About the application

Application number: 2020/93467	
What is the application for?:	Erection of gates and gate posts
Address of the site or building:	Brigsteer, 402, Birkby Road, Birkby, Huddersfield, HD2 2DN
Postcode:

CLIENT:	
ACUMEN	
JOB TITLE:	
GATEPOSTS AT 402 BIRKBY ROAD, HUDDERSFIELD	
DRAWING TITLE:	
PROPOSED SITE PLAN & ELEVATION	
DRAWN: JF	DATE: Sep
CHECKED: JC	SCALE: 1:200 @ A1
DRAWING NUMBER:	2532 - 12

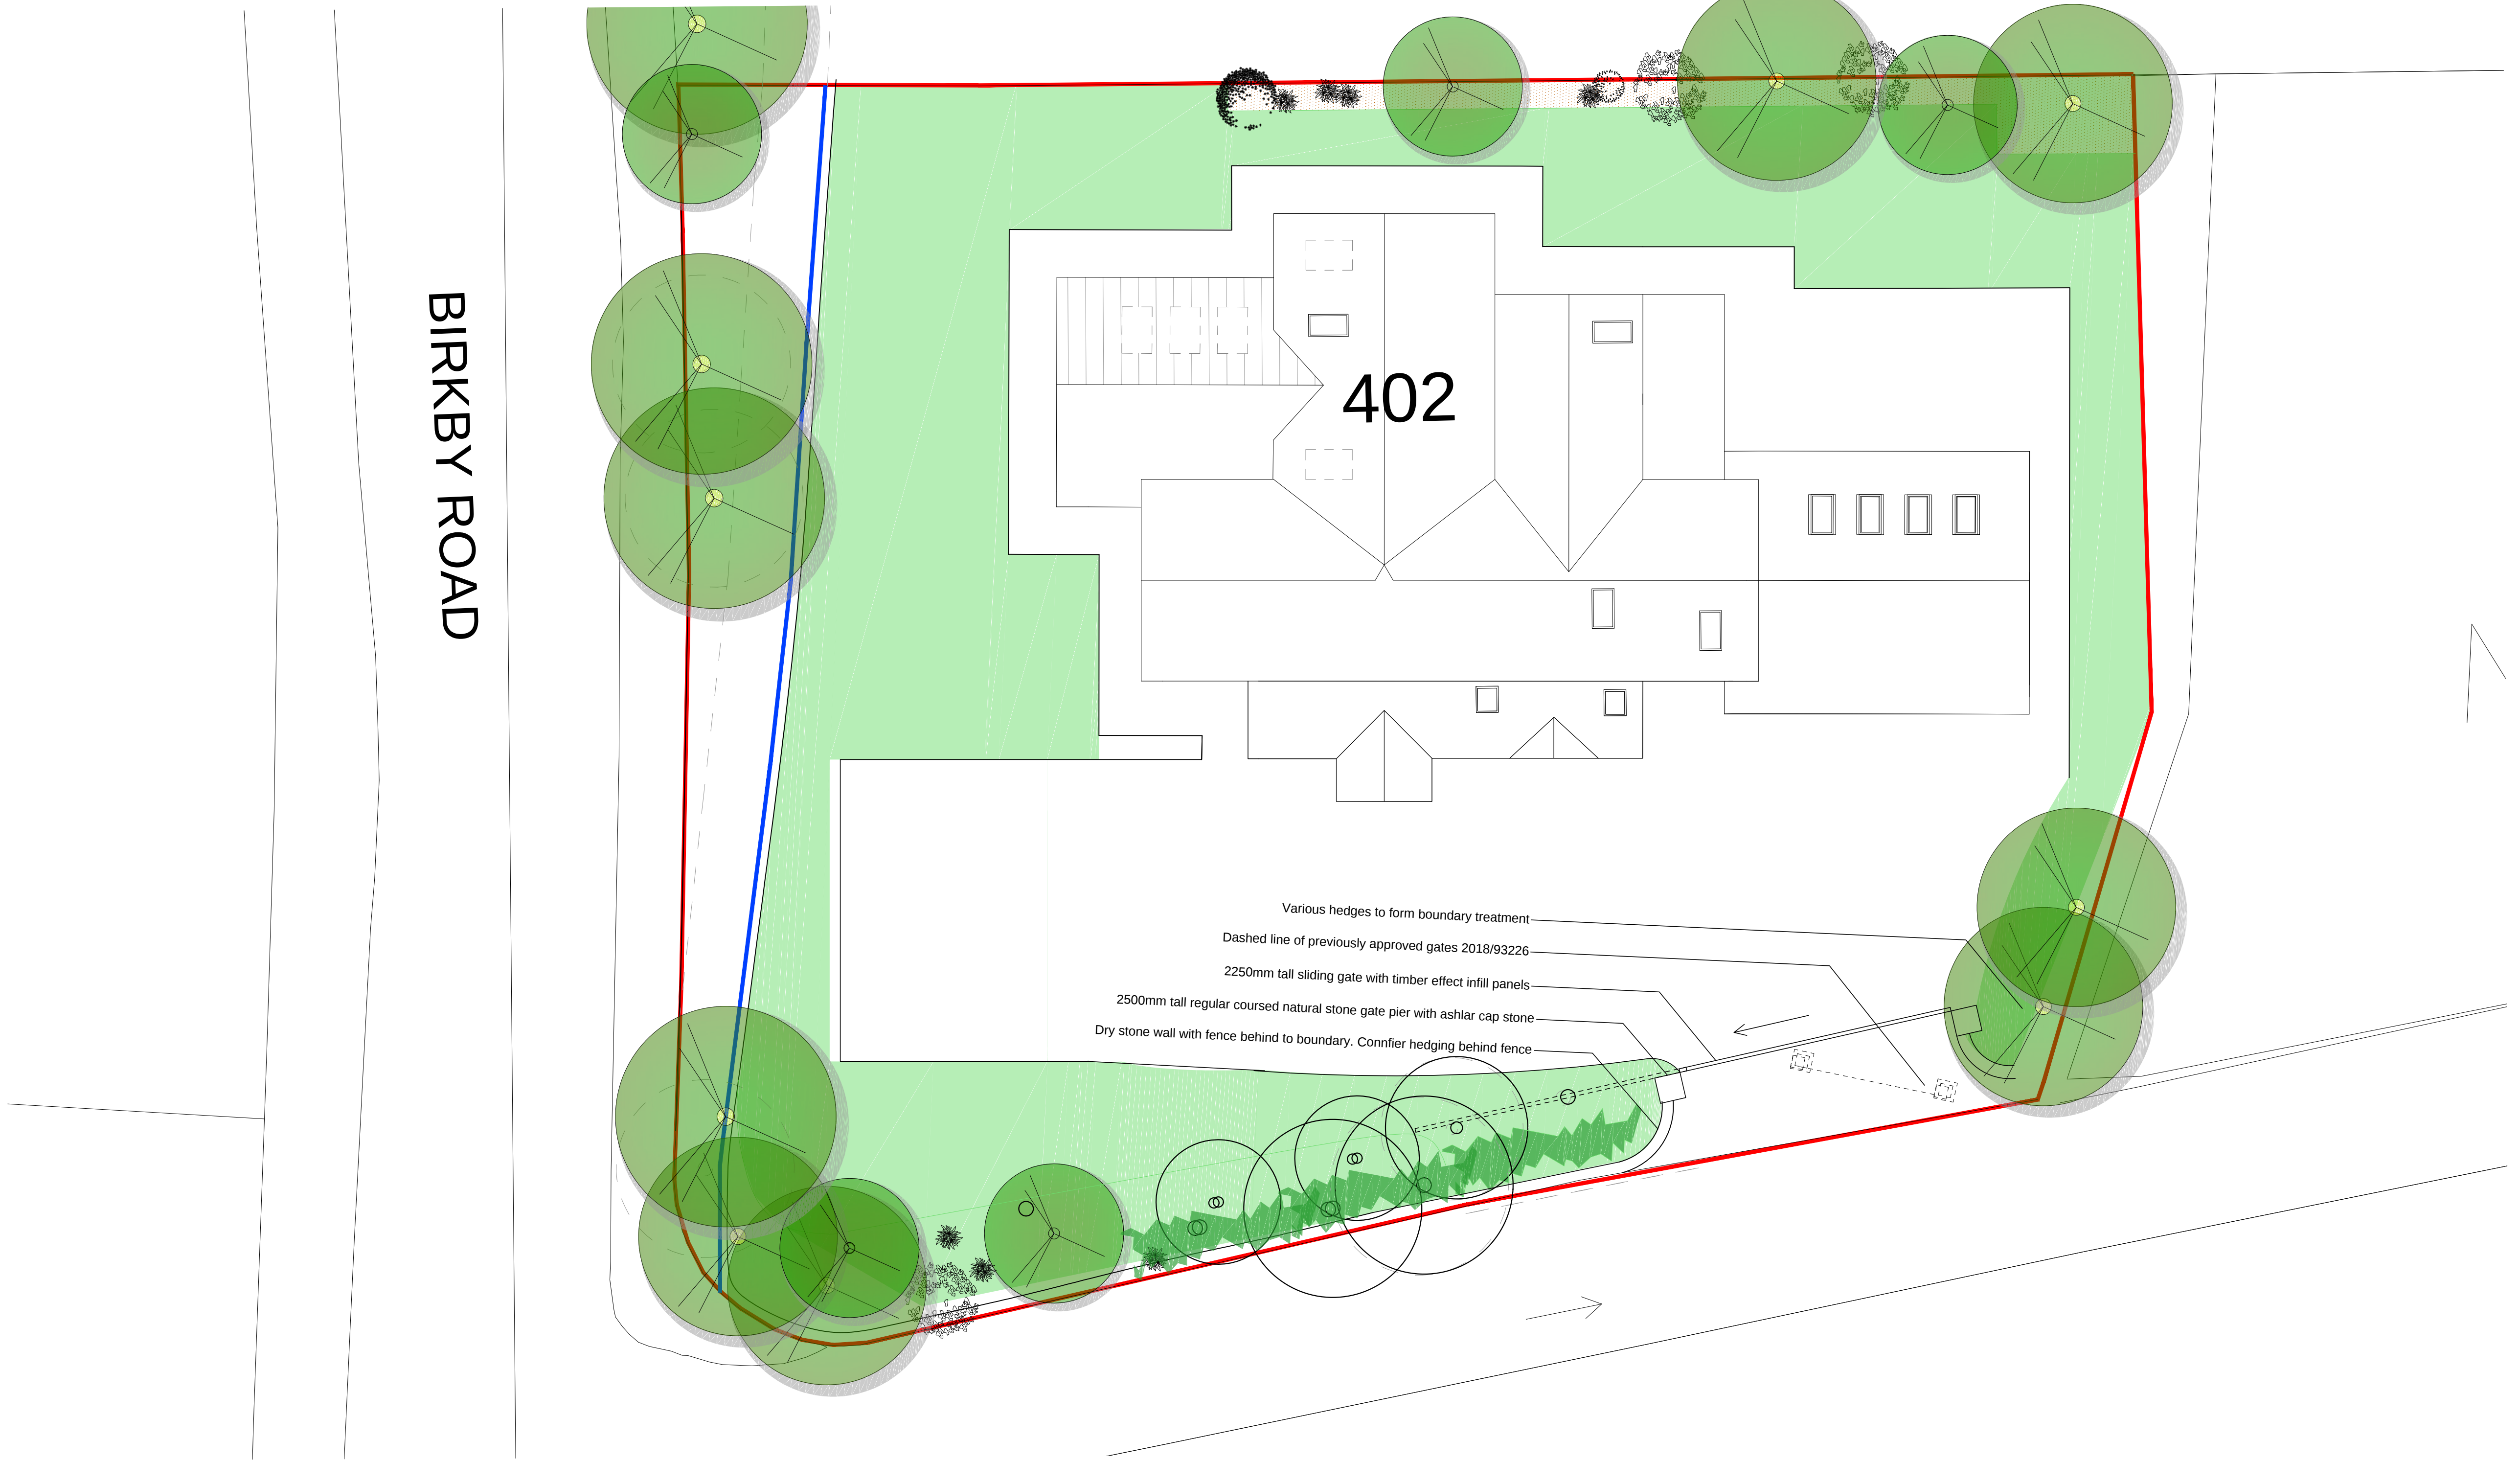
Type of comment: An objection
I wish to object to the recent application for gate posts and gates which have been built prior to an application being submitted and approved/declined. My objection is on the grounds of conservation within the local area. These gate posts are larger than any in the area in both height and width. The gates are not made of natural materials and are more in keeping in height and size of those found on an industrial estate! We are a residential area. I have no objection to an owner wanting to erect a fence, gate posts and electric gates around his property but not to this height and scale. The width of the gates makes them slow to open ensuring other residents on the lane have to wait! For these reasons I would call on the planning committee to refuse this application and work with the owner to reduce the width of his entrance which was refused on previous applications and return the entrance to a more suitable size and in keeping with the residential area and to erect electric gates of a reasonable height as per Kirklees Council guidelines.
